Development Facilitation Team (DFT) – Review Comments

DRB Project No: PR-2021-004968 Date: 02/07/2024 Agenda Item: #8 Zone Atlas Page: C-10

Legal Description: TRACT B-2-A-1, LA CUENTISTA SUBDIVISION

Application For: SD-2024-00020 – FINAL PLAT (DHO)

**Plat for  
La Cuentista Subdivision, Phase II  
Being Comprised of  
Tract B-2-A-1, La Cuentista  
Subdivision, Phase I  
City of Albuquerque  
Bernalillo County, New Mexico  
January 2024**

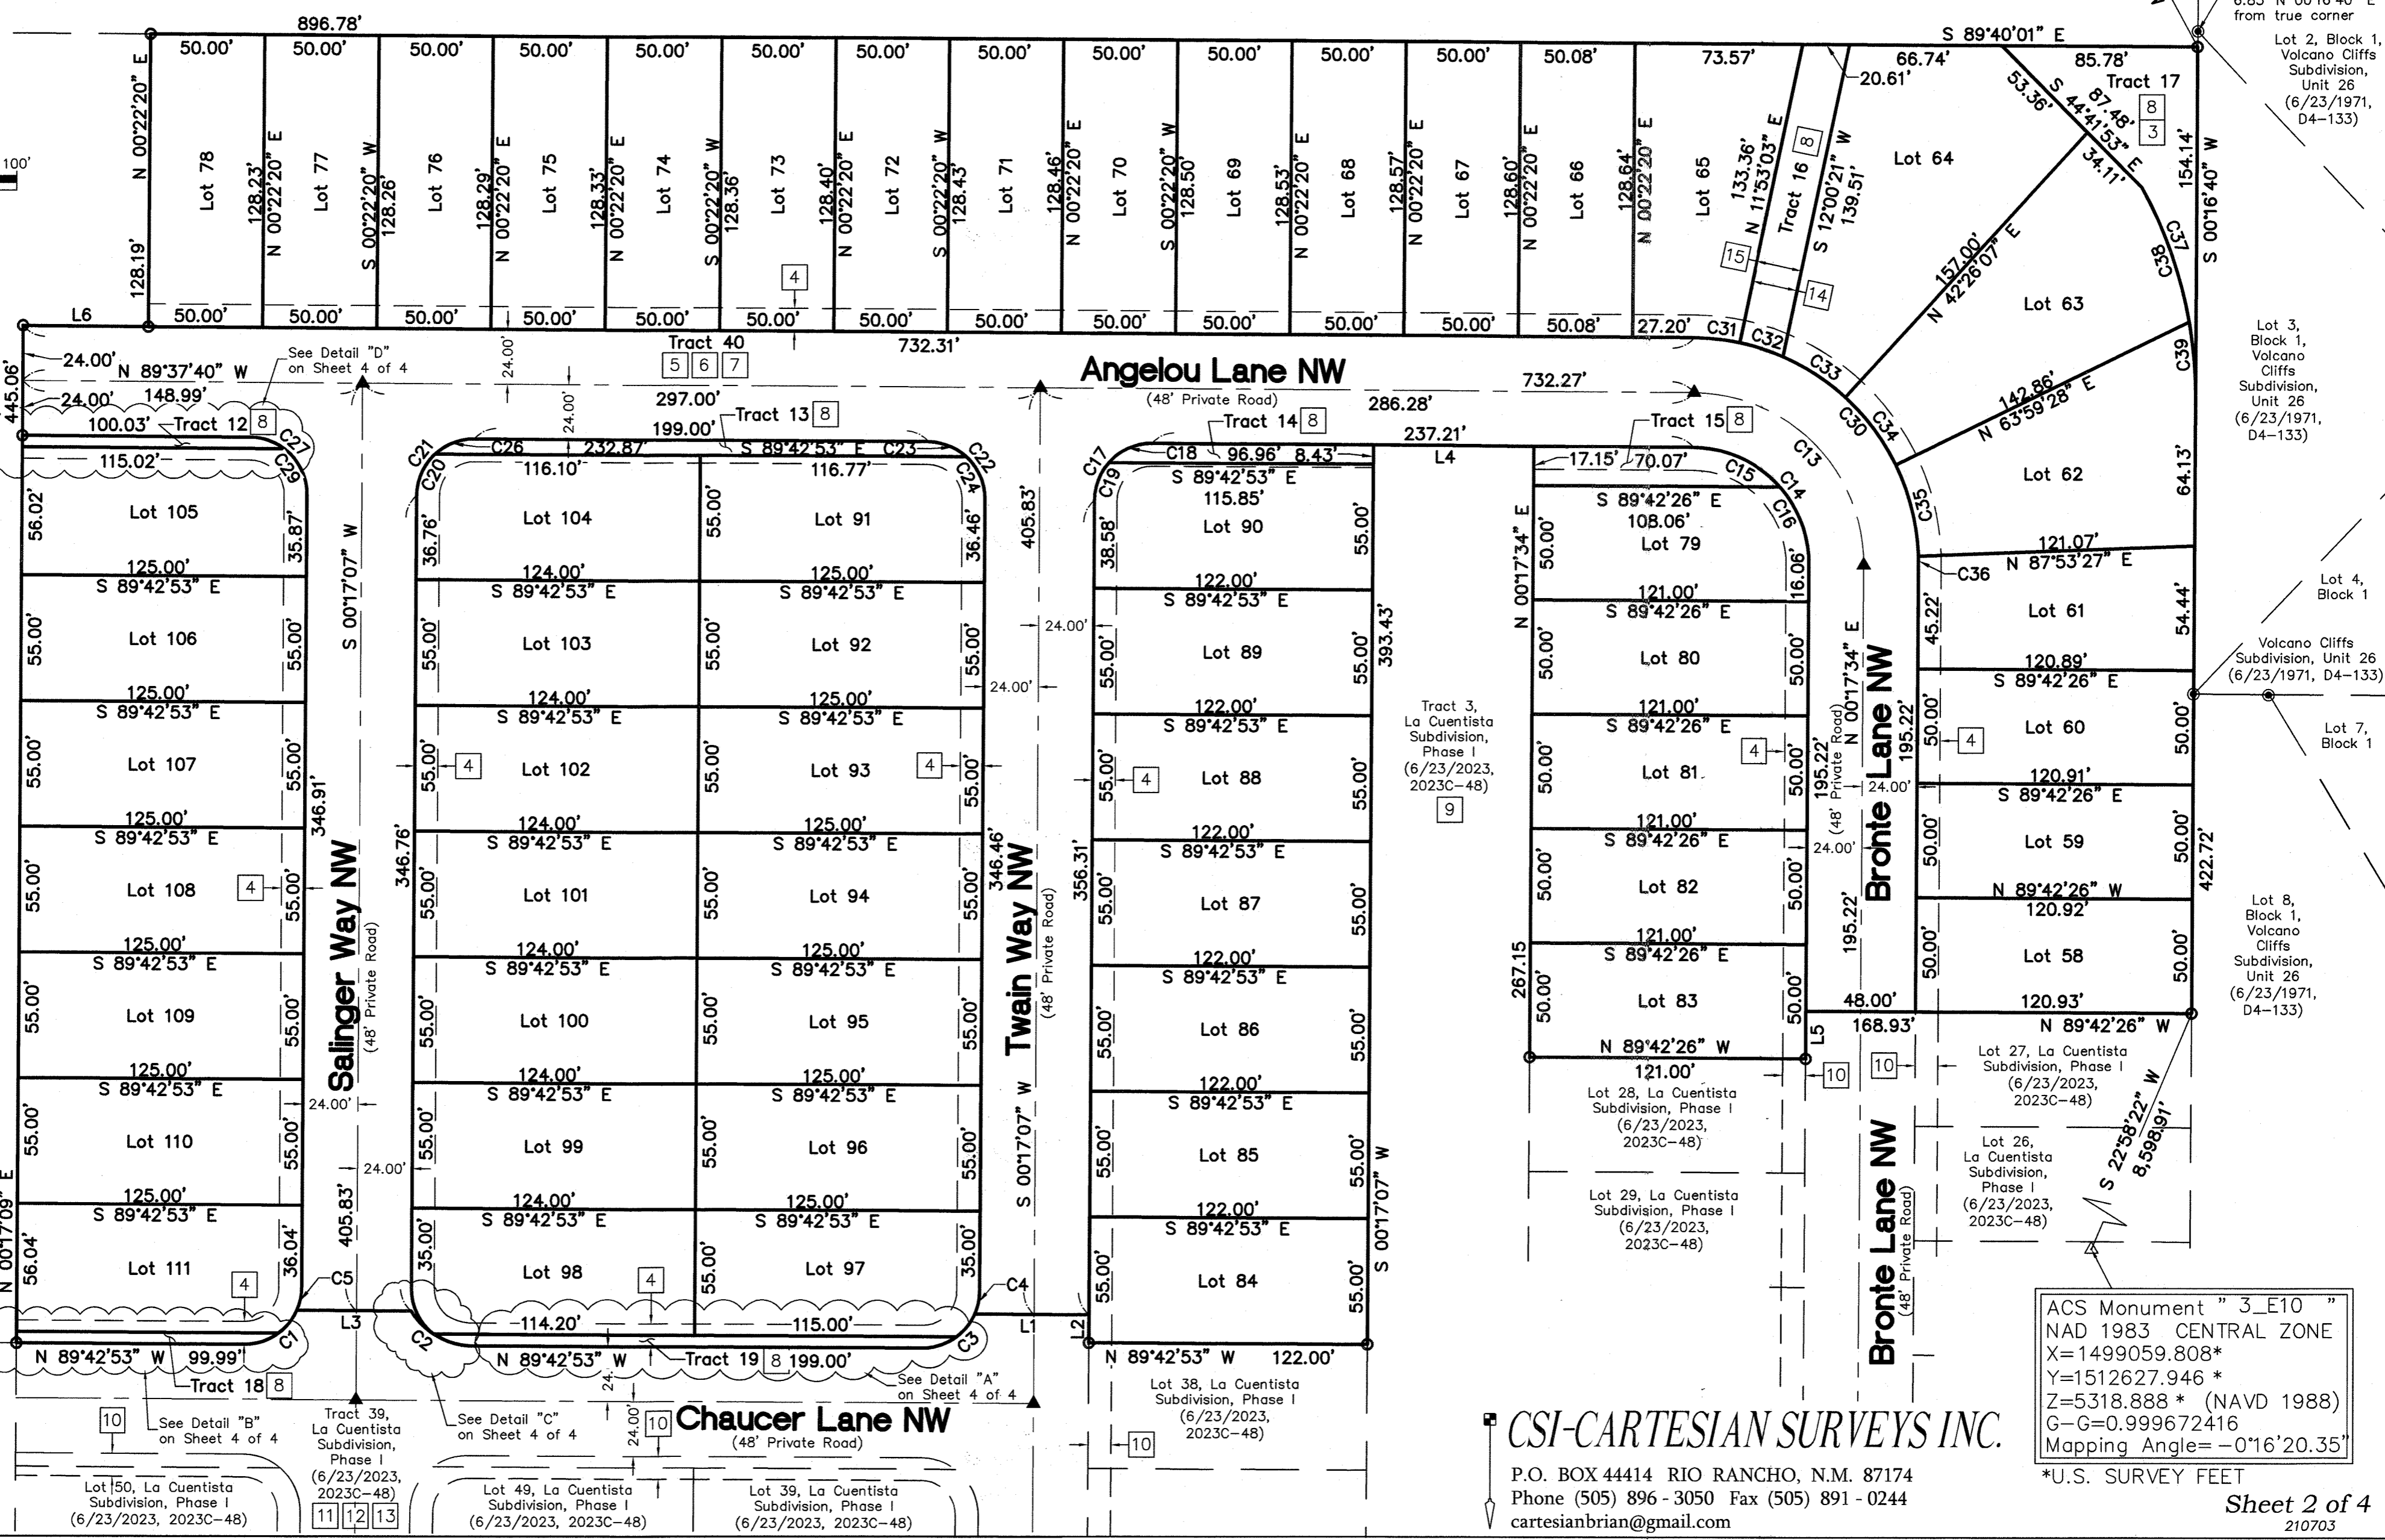
1. Please elaborate on what type of surface is being proposed on Tract 16.
 - a. The exclusive easements are preferred.
2. Add the following note on the plat when easements are being granted for public water and/or public sanitary sewer infrastructure.

It will be a trail connection to future paseo

This is already added
